SLR Project No.: 501.065557.00001

RE: Keohane Readymix Ltd. – Planning Application for Extraction of Sand & Gravel at Knockroe, Bandon, Co. Cork.

Planning Ref. 25/04666 - Further Information Response

**PROPOSED LANDSCAPE AND RESTORATION PLAN**

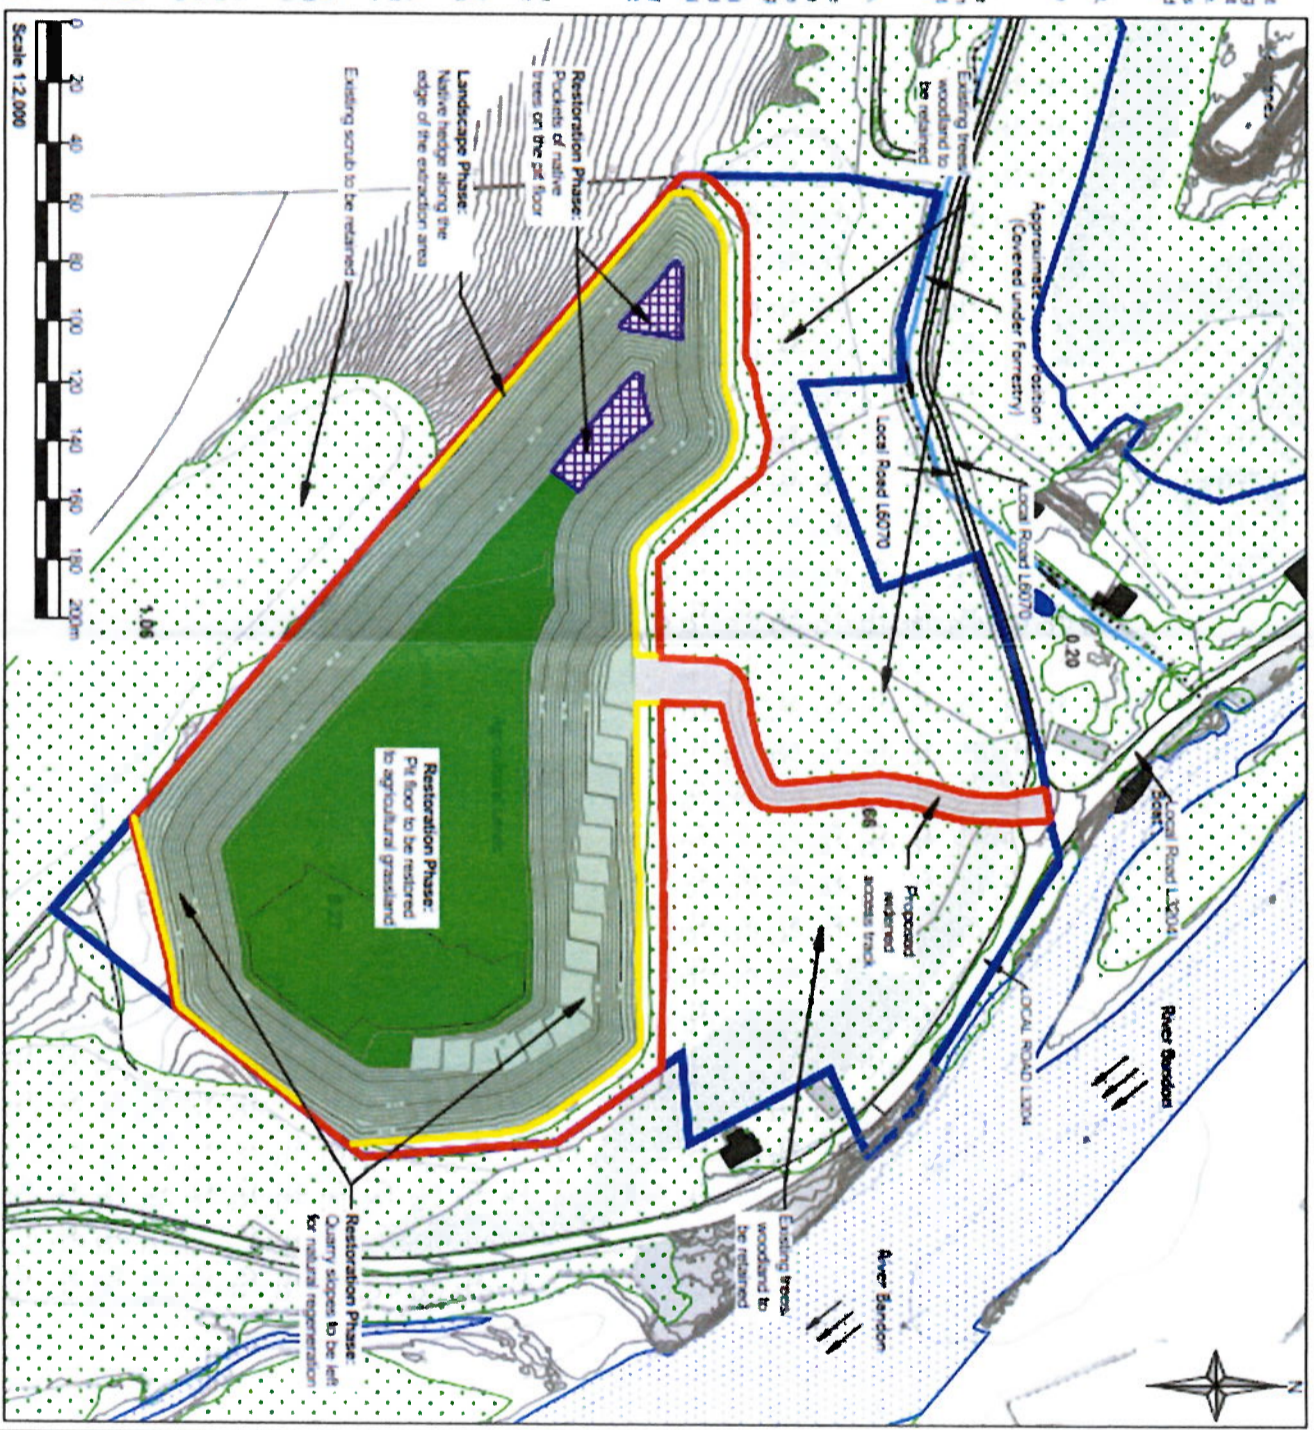
- d. *Biodiversity net gain measures at the end of the development, per the restoration plan, are not sufficient as they are planned for over 15 years after the removal of scrub habitat. More immediate measures to address the net loss of biodiversity are required. The revised Chapter should include these measures and have reference to the Tree Survey Report.*

As detailed in EIAR Chapter 2 there will be a “landscape phase” which will comprise a planting scheme and habitat creation that will take place upon commencement of the development. The landscape phase will include the following elements:

- Retention of all existing trees/scrub/woodland vegetation within the land interest boundary with the exception of the small number of trees/scrub vegetation along the proposed access track, refer also to the separate Tree Survey report submitted in response to Item 9 of the Request for Further Information.
- The planting of 660 m of diverse native hedgerow along the northern and part of the south-western and eastern boundaries of the proposed extraction area to mark/secure the edge of the pit slopes, provide habitat linkage and compensate for the loss of existing tree/scrub, refer to Figure RFI 9-1 Compensatory Planting Details (including planting schedule) and Compensatory Planting Map submitted in response to Item 9 of the Request for Further Information.

Details of the landscape and restoration phases are set out in EIAR Figure 2-5 in Appendix A, refer to separate RFI Item 8 Biodiversity report enclosed separately.

This initial landscape phase planting is significantly larger and more valuable than the habitat than the poor condition scrub that will be removed and that will mitigate against the loss of scrub at the Site and ensure a net gain for biodiversity at an early stage of the development.

Drawing Title
**RFI Item 9:
Tree Survey and Compensatory Planting Plan**

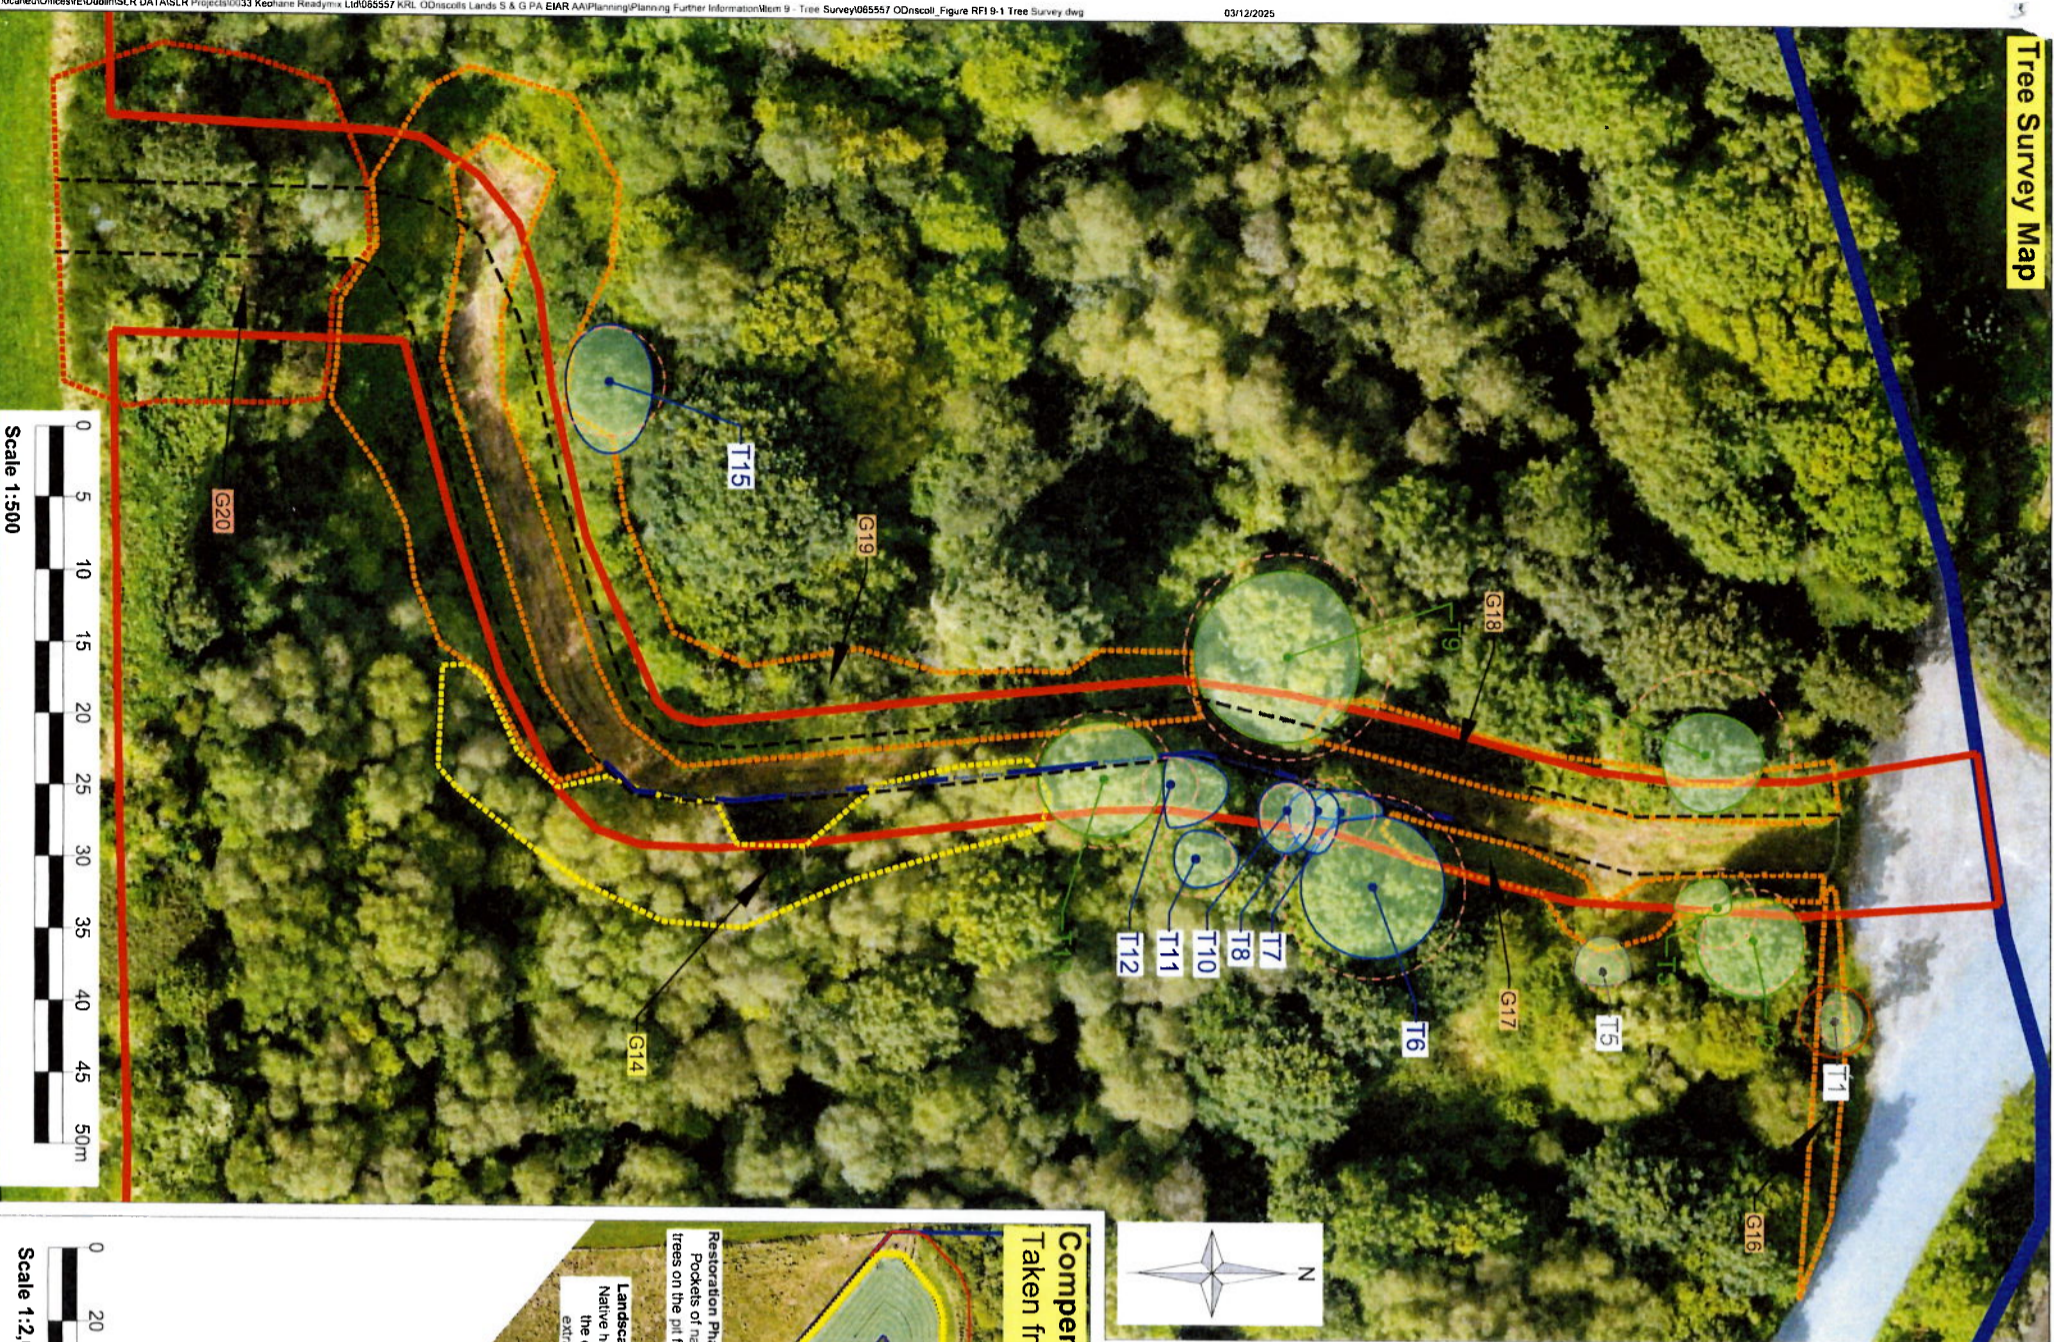
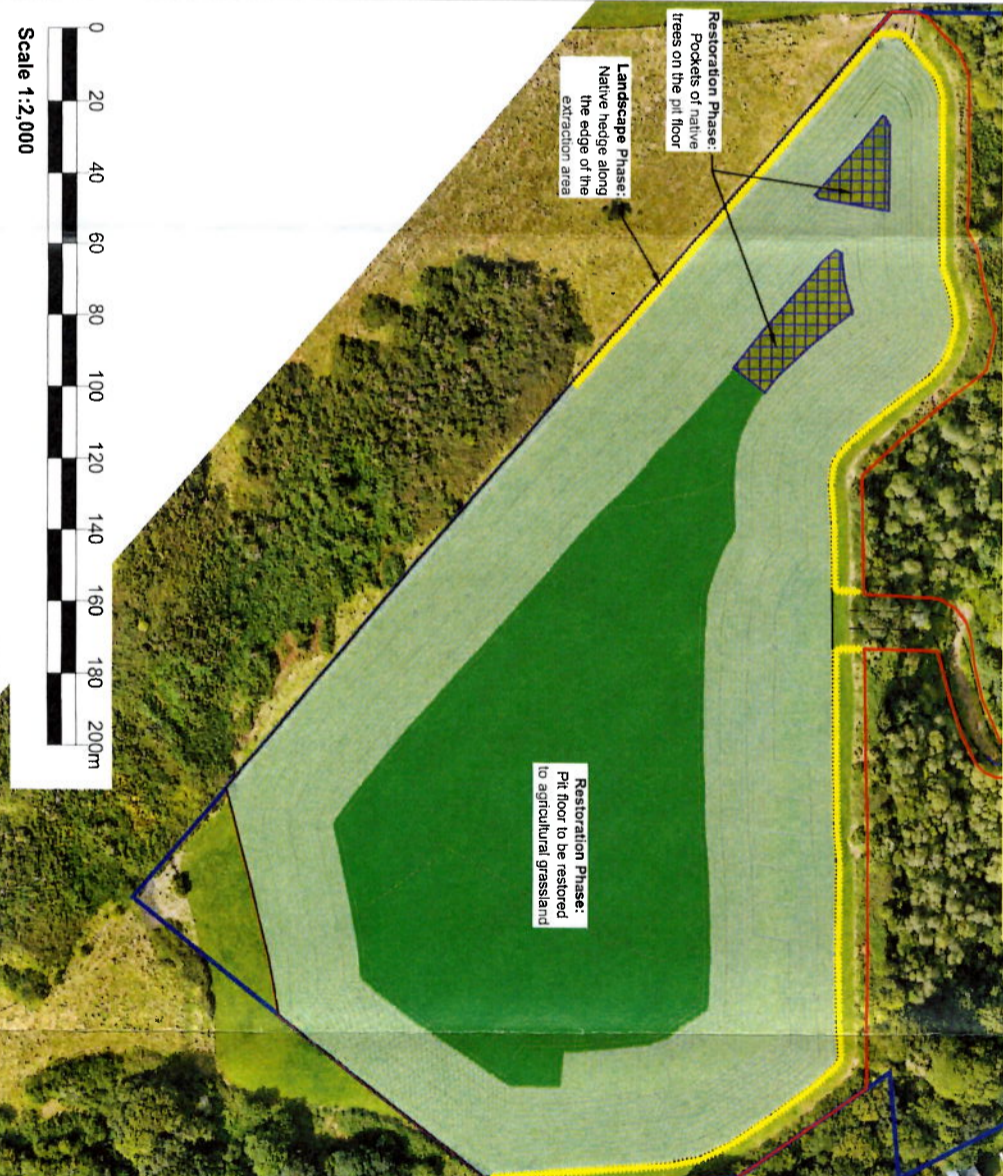
- Identify the age, species, and condition of all trees within the site.*
- A site layout plan, identifying all the trees on the site.*
- Identify which trees are required to be removed to facilitate the development.*
- The tree protection measures which will be implemented on the site to protect the trees for retention.*
- Details of compensatory planting on the site to ensure that there is no net loss of biodiversity on the site.*

- Identify the age, species, and condition of all trees within the site.
- A site layout plan, identifying all the trees on the site, refer to Figure RFI 9-1.
- Identify which trees are required to be removed to facilitate the development, refer to Section 2.2 of the enclosed report and Figure RFI 9-1
- The tree protection measures which will be implemented on the site to protect the trees for retention, refer to Section 2.3 of the enclosed report and Figure RFI 9-1.
- Details of compensatory planting on the site to ensure that there is no net loss of biodiversity on the site, refer to Section 2.4 of the enclosed report and Figure RFI 9-1. This information includes Compensatory Planting Details (including planting schedule) / Compensatory Planting Map to be implemented during the initial landscape phase, and it will ensure no net loss of biodiversity on the site.

Drawing PL05: showing Proposed Site Layout and access route through woodland habitat

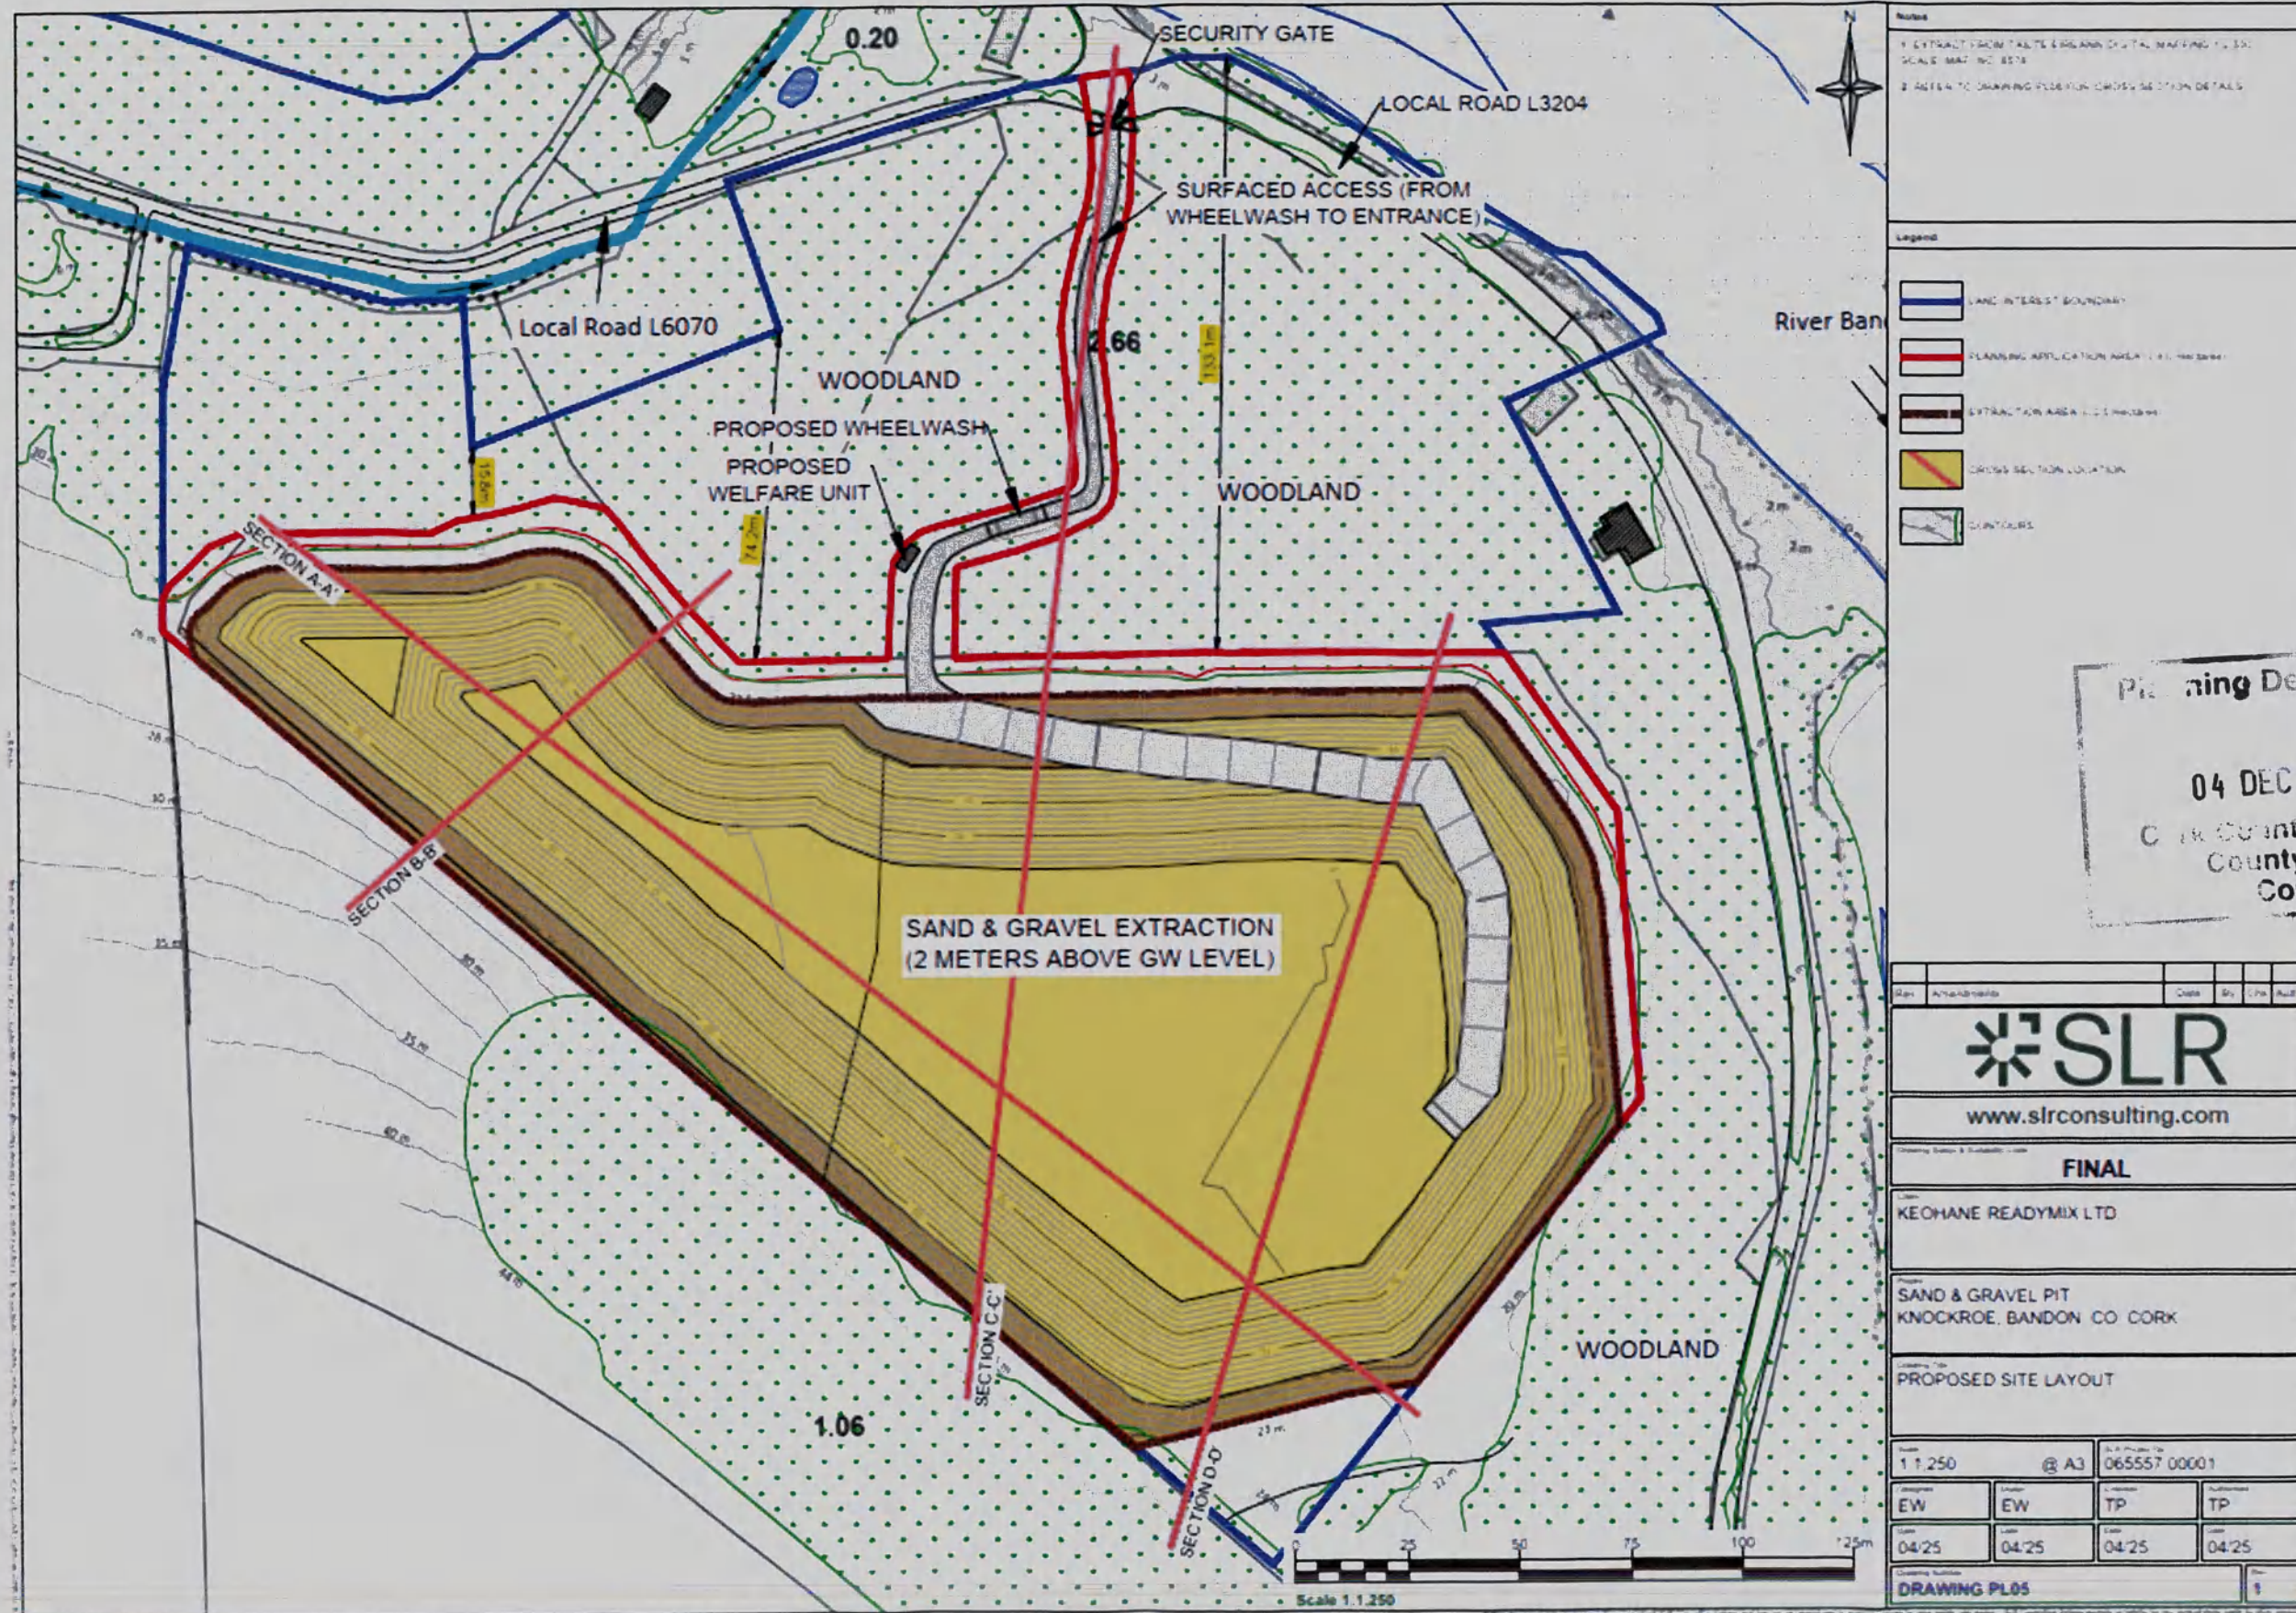
- b. *Clarification on the potential loss of woodland habitat as a result of the installation of the welfare unit (per drawing no. PL05).*

There will be no loss of woodland habitat to facilitate the installation of the welfare unit. The original planning application Drawing PL05 (refer to Appendix A of the separate RFI Item 8 Biodiversity report enclosed) did distinguish between woodland habitat and scrub / open scrub mosaic habitat. However, the more accurate habitat map, EIAR Figure 5-1, submitted as part of the Biodiversity Chapter of the original EIAR (refer to Appendix A of the separate RFI Item 8 Biodiversity report enclosed). It is clear from Drawing PL05 and Figure 5-1 that the welfare unit will be installed within an area that is currently a mix of scrub and open scrub mosaic habitat. These scrub and woodland habitats have been further assessed within the revised EIAR, and with the suitable mitigation implemented there will be no significant residual effects on the woodland habitat or any other habitats of the Site following the removal of a small amount of vegetation to allow for installation of the welfare unit.
